GRANDVIEW RESERVE PHASE 3 EARLY GRADING & EROSION CONTROL PLAN

NOT FOR CONSTRUCTION LAND USE REVIEW FILE NO: PUDSP-241

EARLY GRADING AND EROSION CONTROL PLANS
 EARLY GRADING & EROSION CONTROL PLANS

SHEET GEC 9

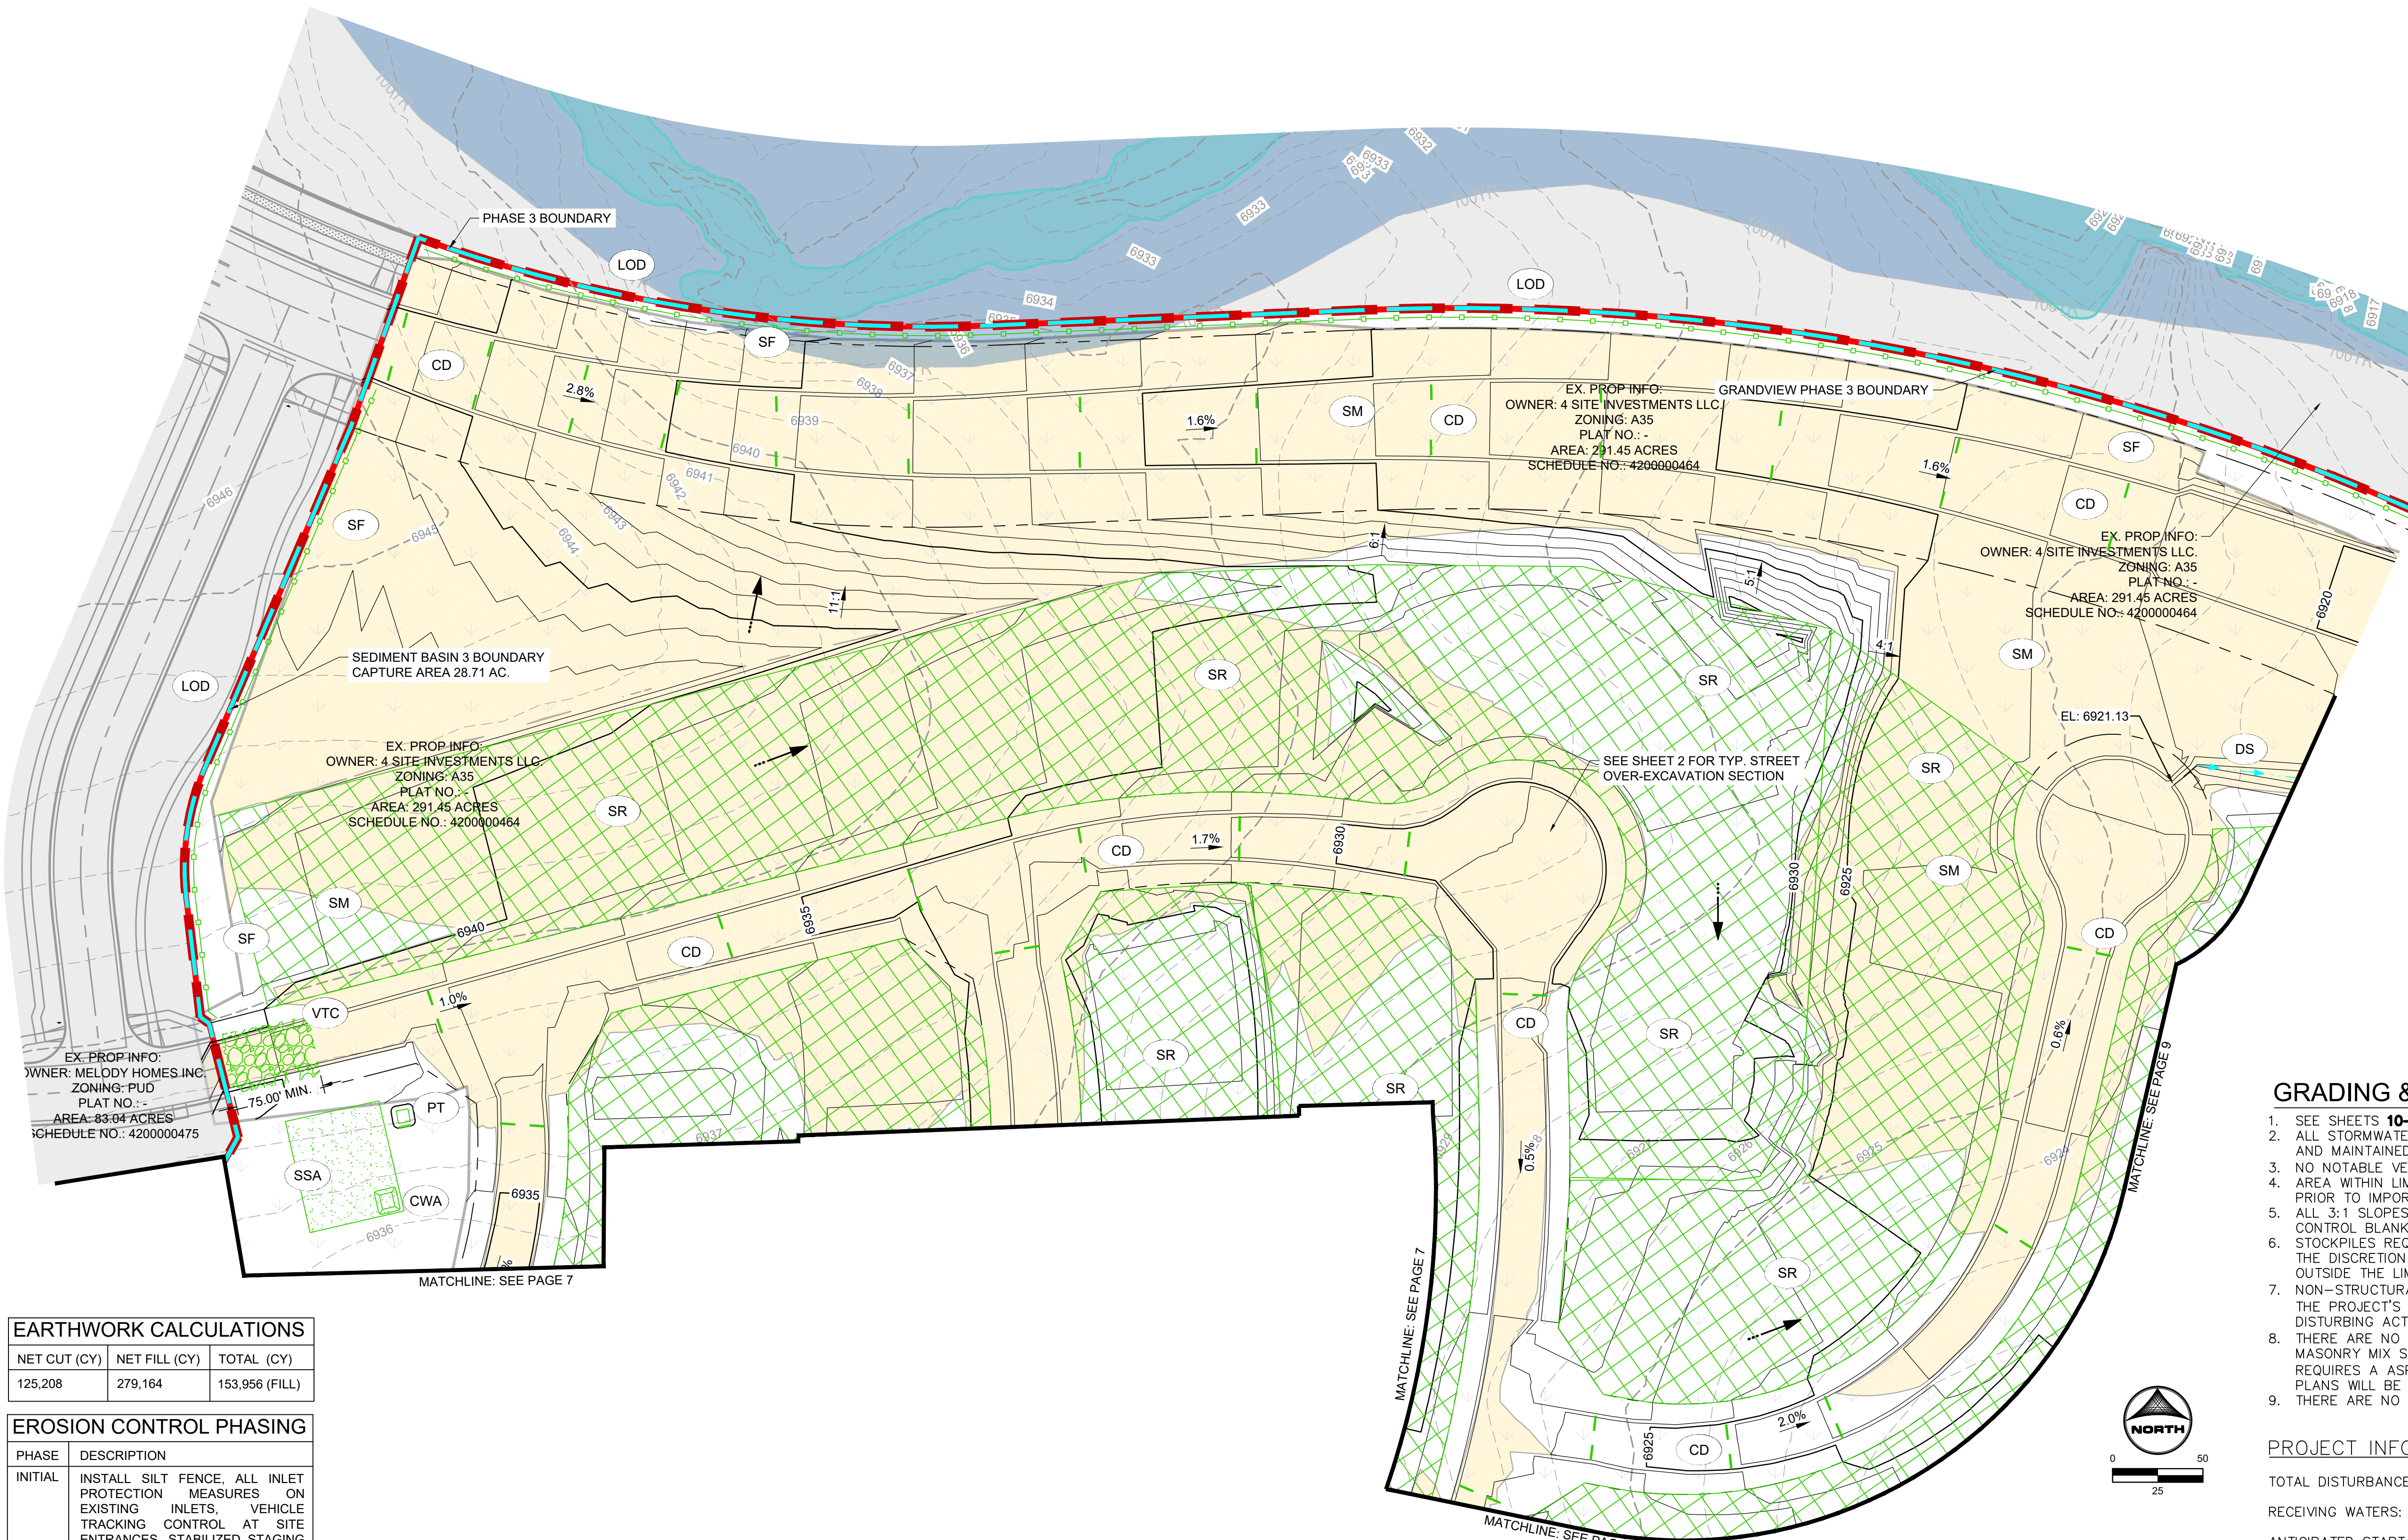
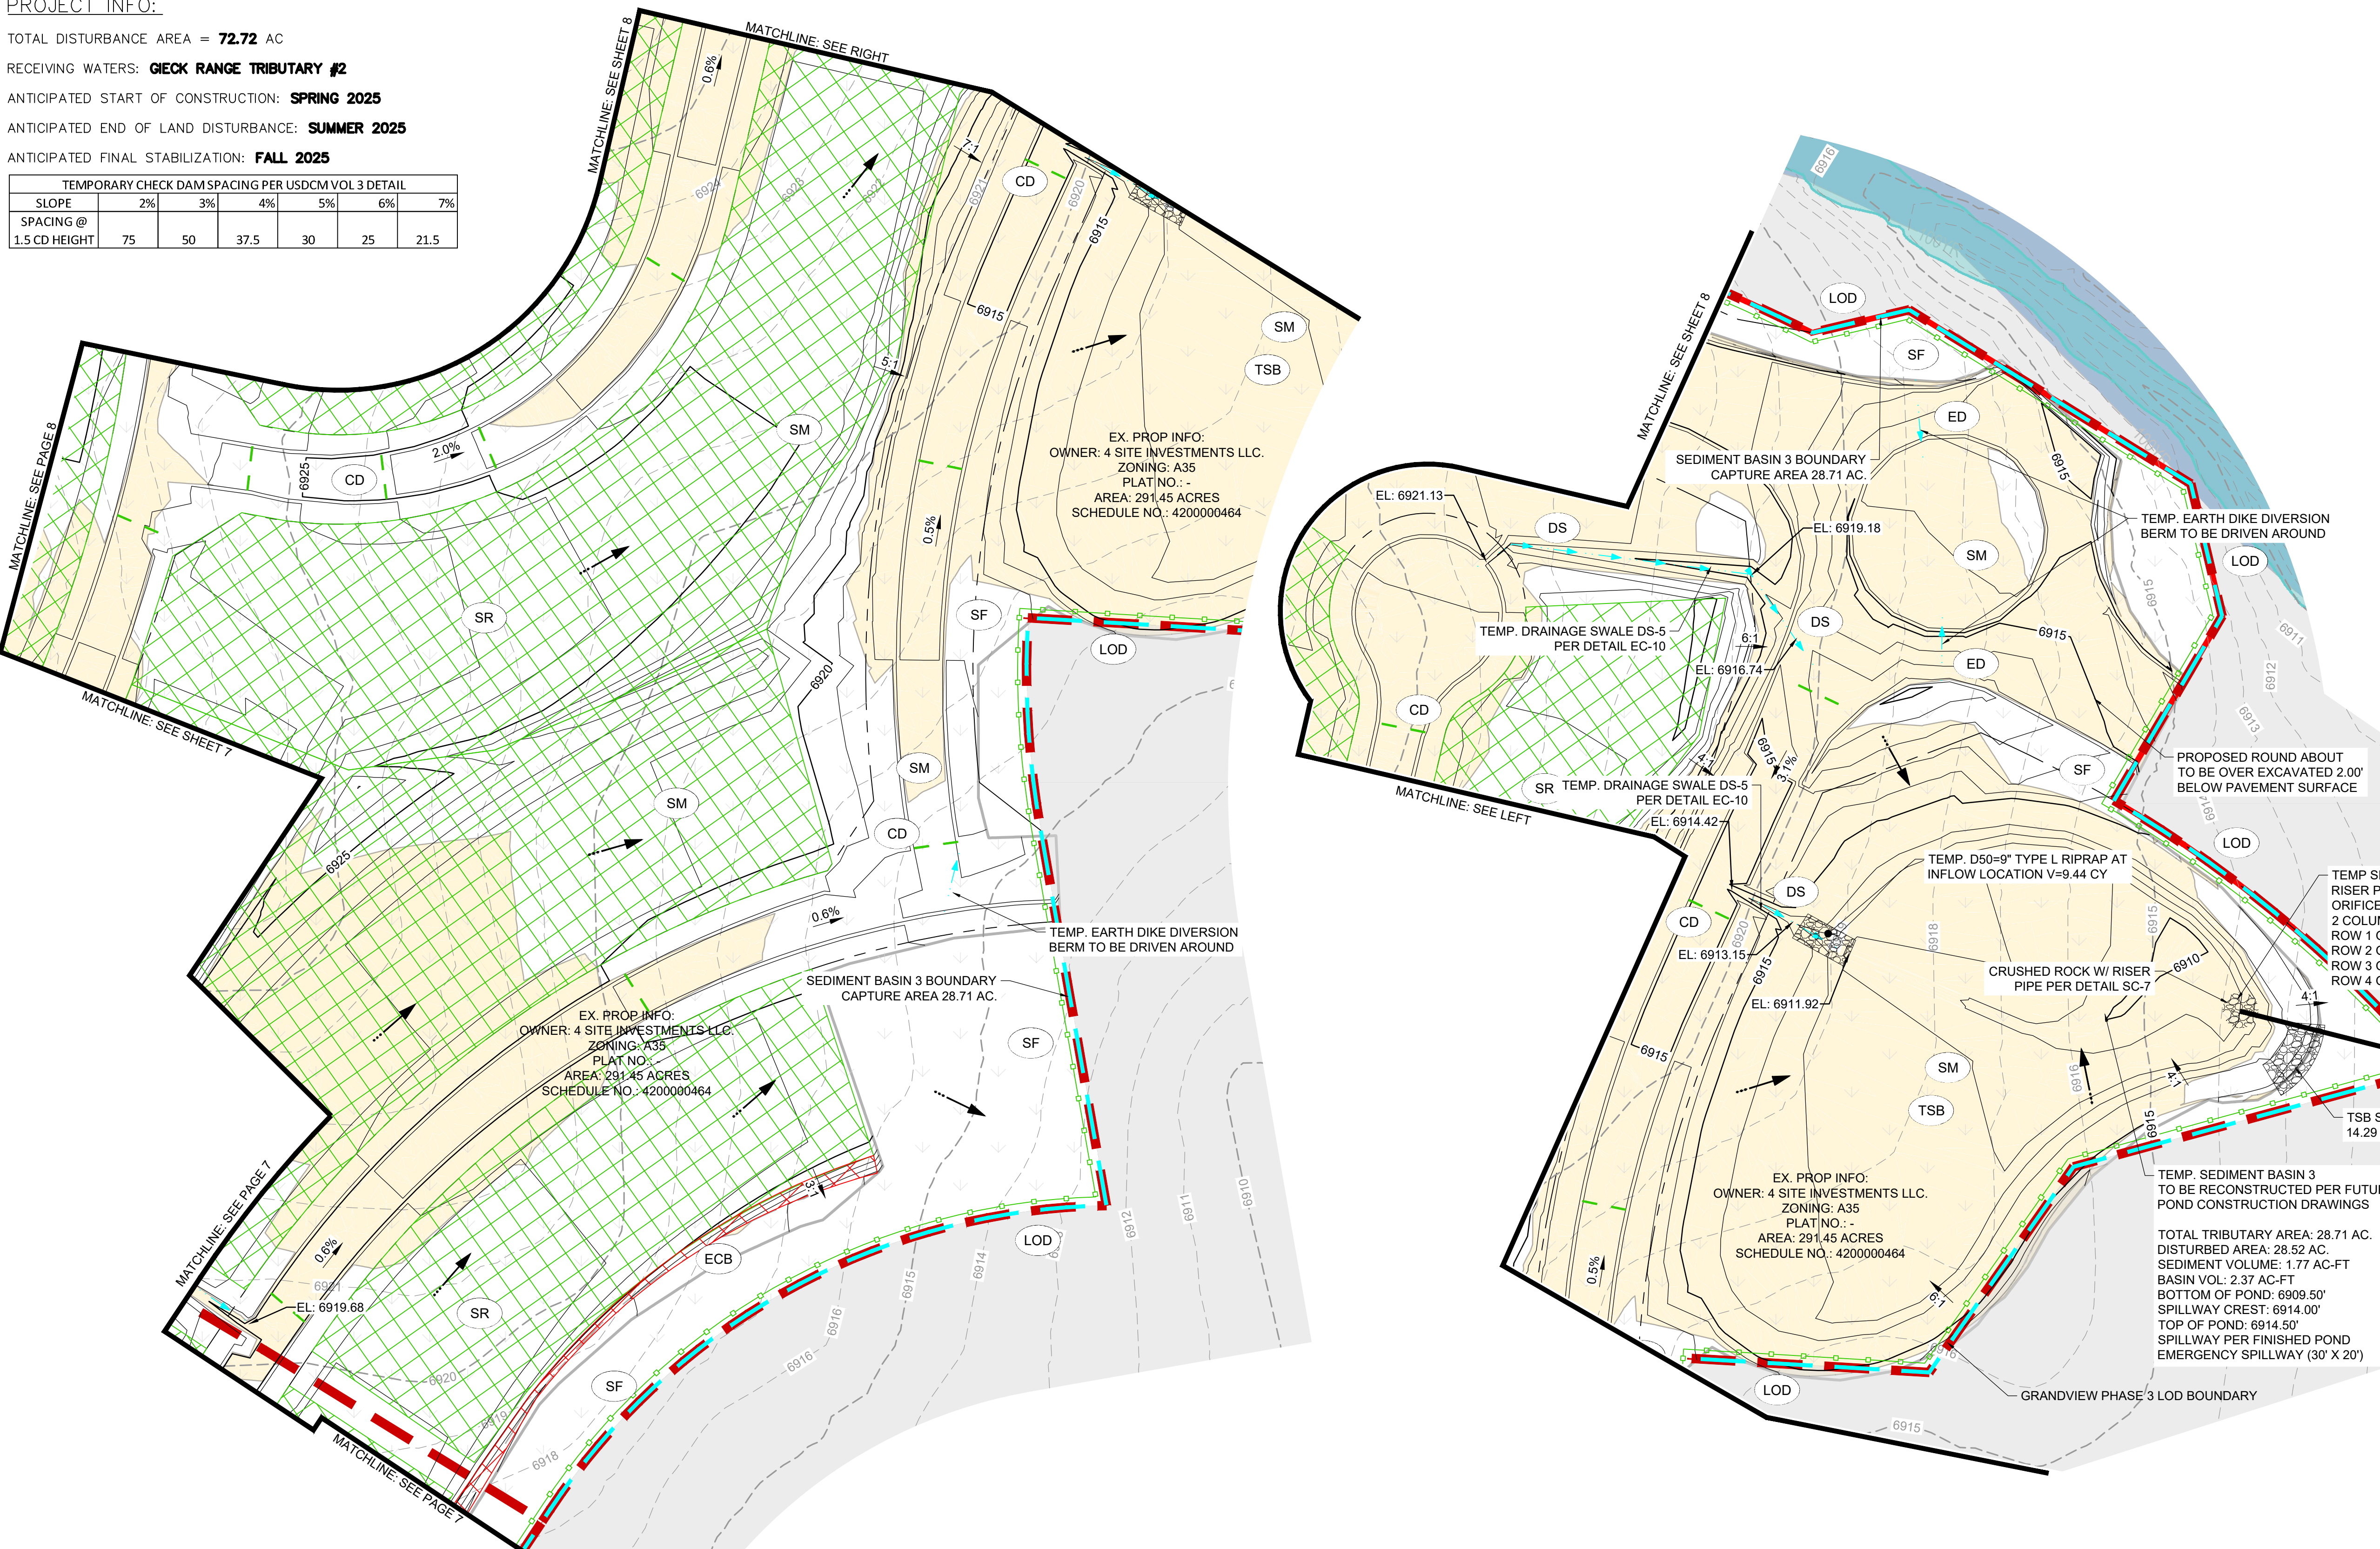
Verify this is a suitable outfall. There is no erosion protection and the runoff is going from a concentrated flow location to a location that is historically sheet flow (or appears that way). Also this is showing work in the floodplain which cannot be completed until the CLOMR and channel improvements are completed.

SHEET  
GEC

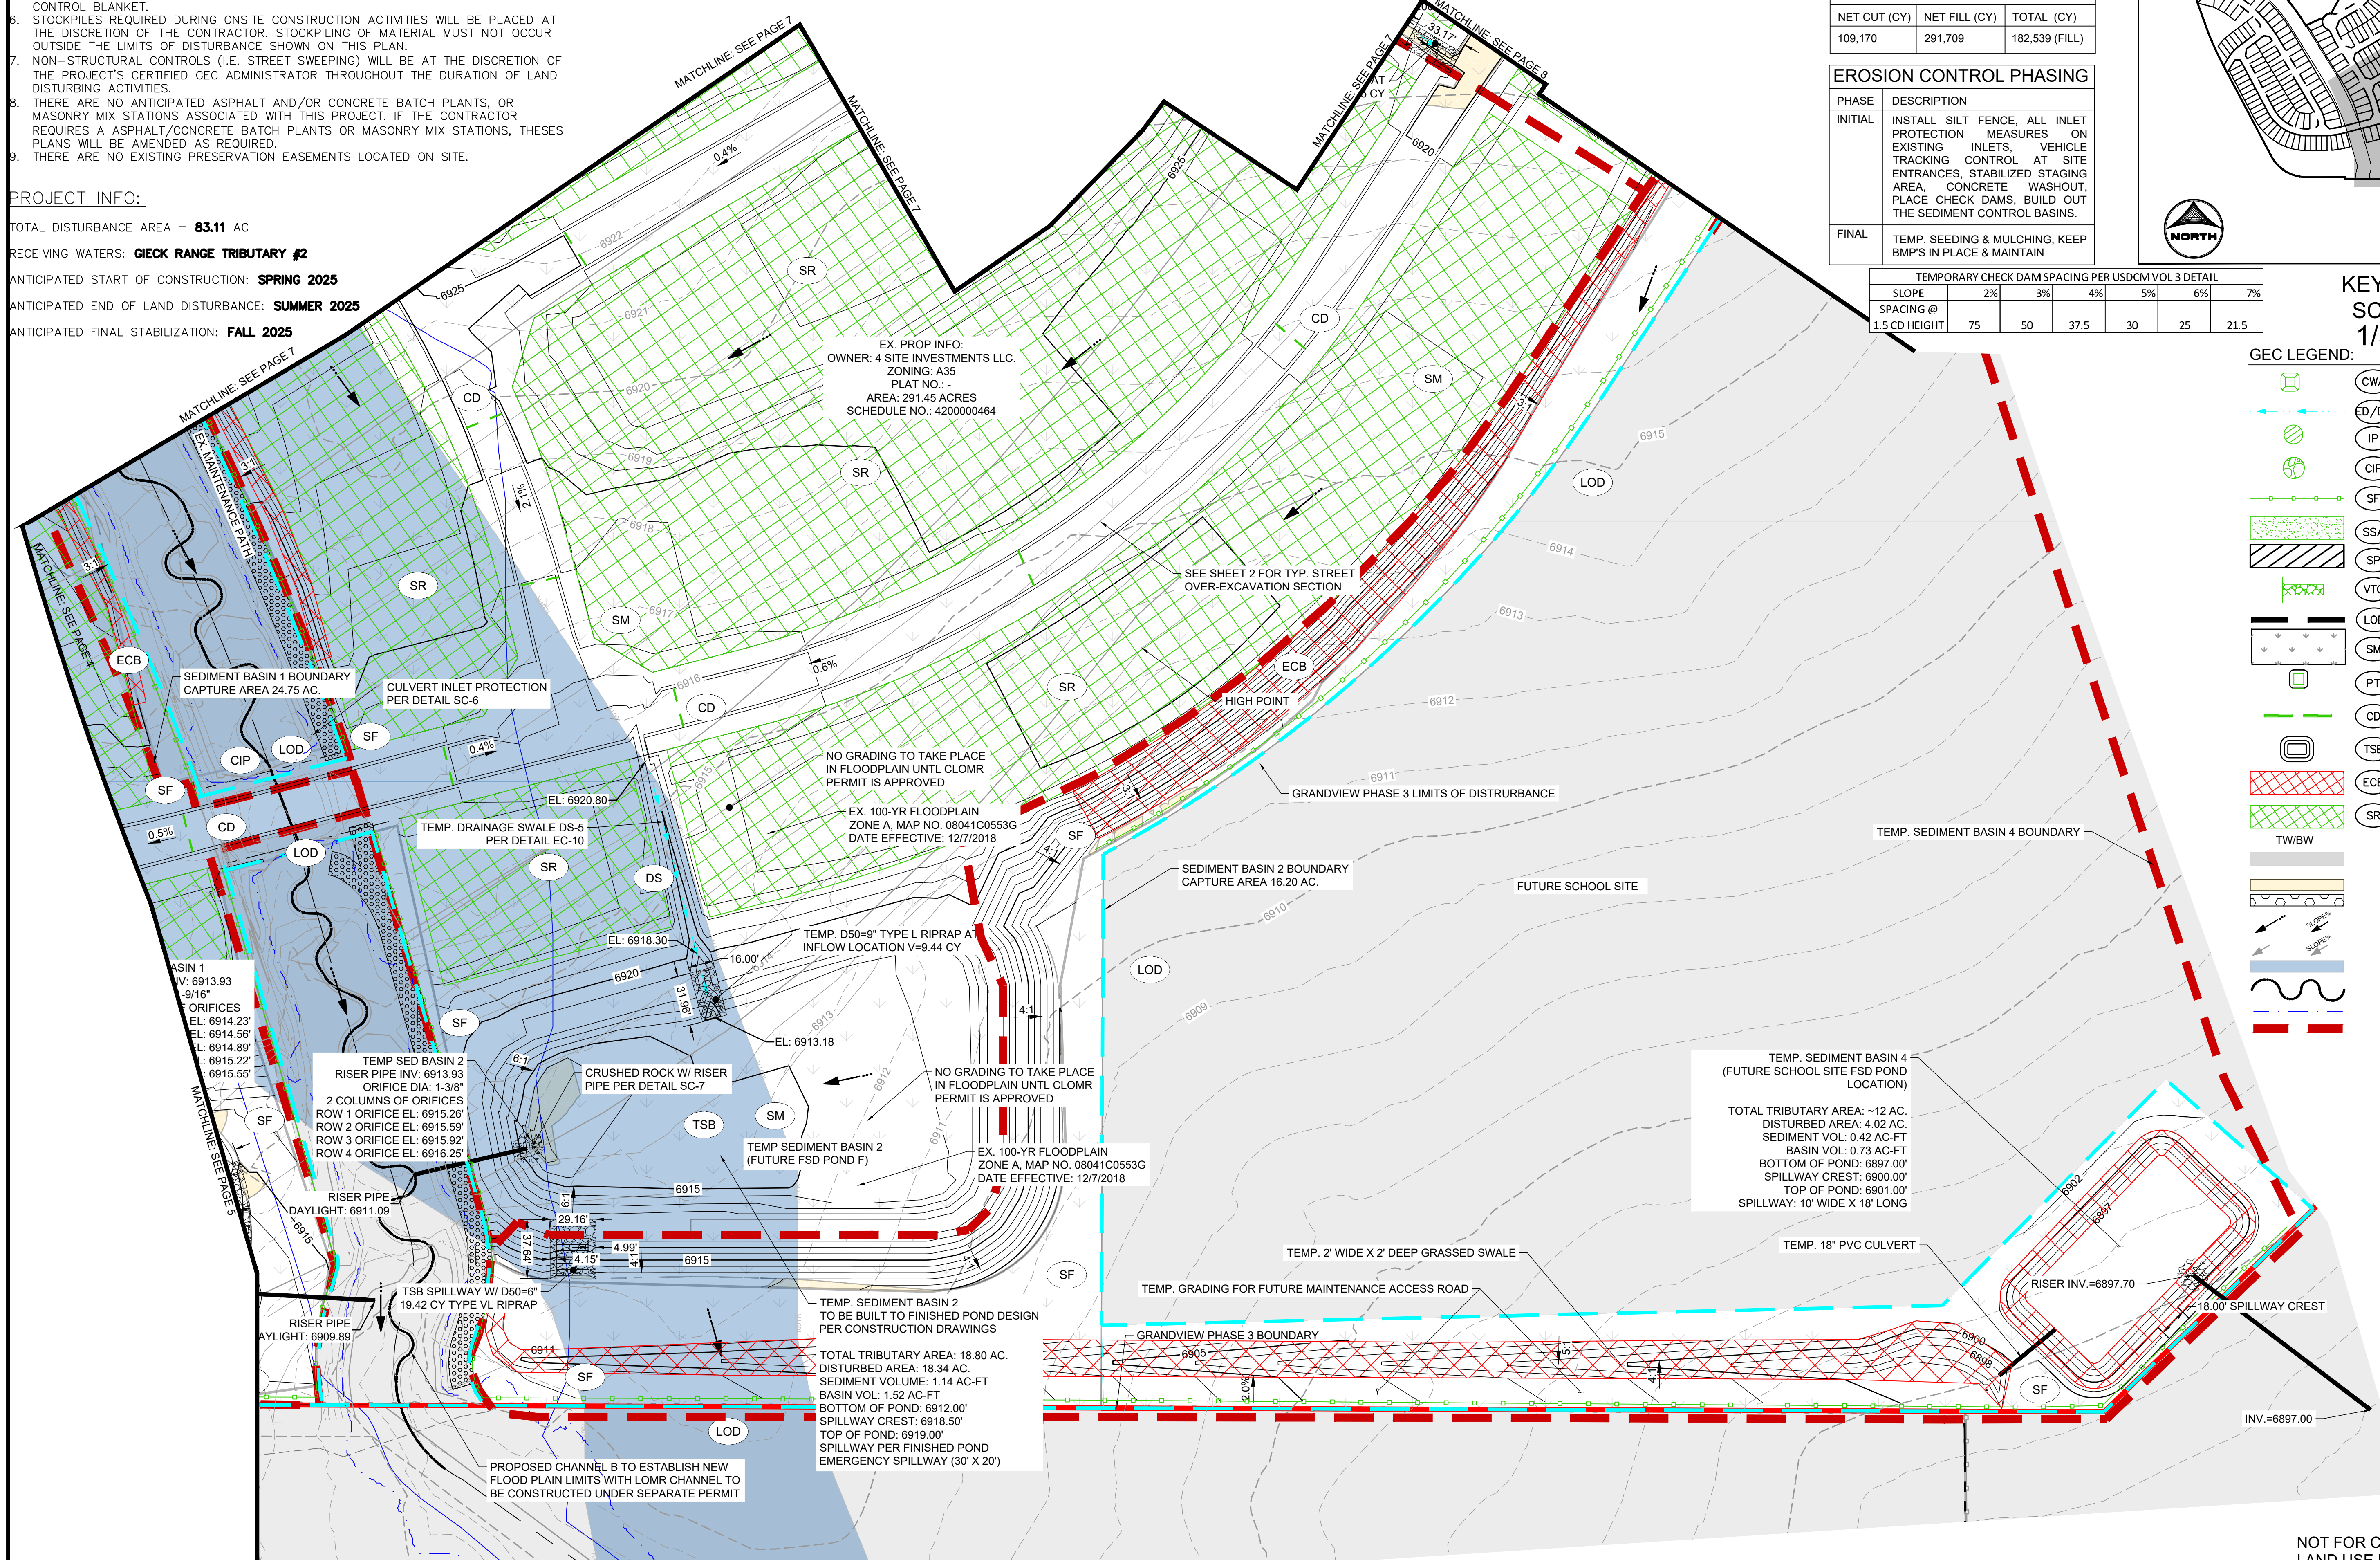
Unresolved from Submittal 1:
Provide outfall protection with the TSB so that it will have a suitable outfall location and not result in erosion.

Incorporate soils report recommendations for all ponds. Geotech recommends installation of a clay liner or geosynthetic liner to prevent groundwater from entering the basin if groundwater is present within 2 feet of the pond bottom. Typical comment for all ponds.
